APPLICATION NAME: BOWDENS SILVER MINE AMENDMENT
APPLICATION NUMBER: SSD5765
VISUAL IMPACTS

I **object** to this proposal (SSD 5765).

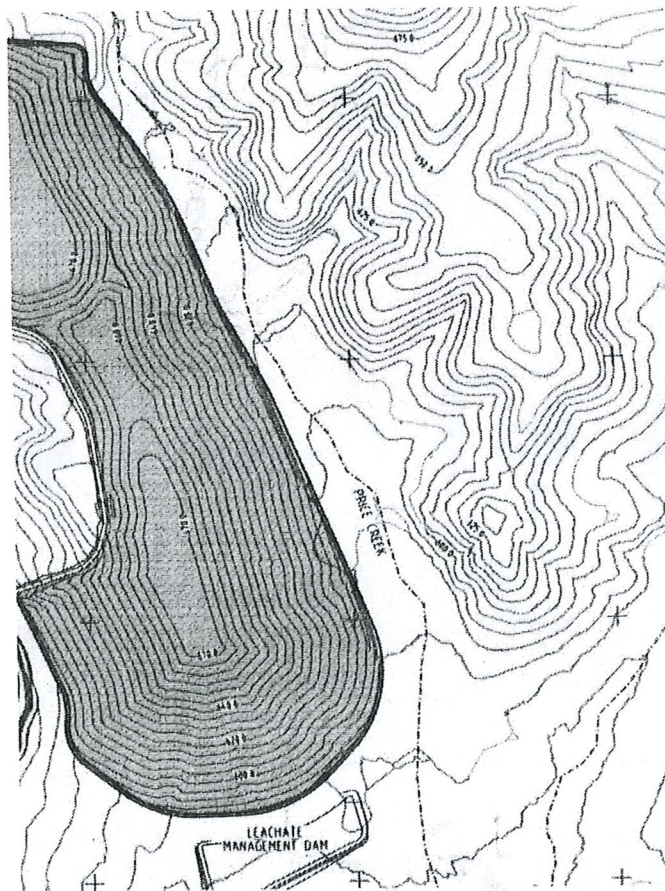
As I asserted a 100 metre high sand castle shaped pile of rocks is a negative outcome and should not be allowed. Is the reader of the proposal documents looking at drawings meant to conclude any different. Simply described the WRE is:

Over one Kilometre long

It is 100 metres high

It has slab or planar sides without any natural contour design (nothing like the hills behind it)

The slab sides are at a constant angle of about 25 degrees

The slab sides meet at a ridge (narrow with enough room for single vehicle track)

The ridge is near enough to horizontal (dead straight like a cottage roof or a railway siding grain shed.)...totally unnatural.

This is an appalling feature to foist onto our visual experience but Bowdens propose to leave it like that for ever. Look at it graphically this is a Bowdens map of the WRE.

The shaded mass is the WRE. All but for a tiny wiggle the contours are straight. They are also equally spaced...meaning constant slope. To the right (east) of Price Creek is natural landform. Chalk and Cheese. And furthermore those tiny wiggles are at such a scale invisible; they could simply appear as rough dozer work. It is time for some honesty about the proposal.
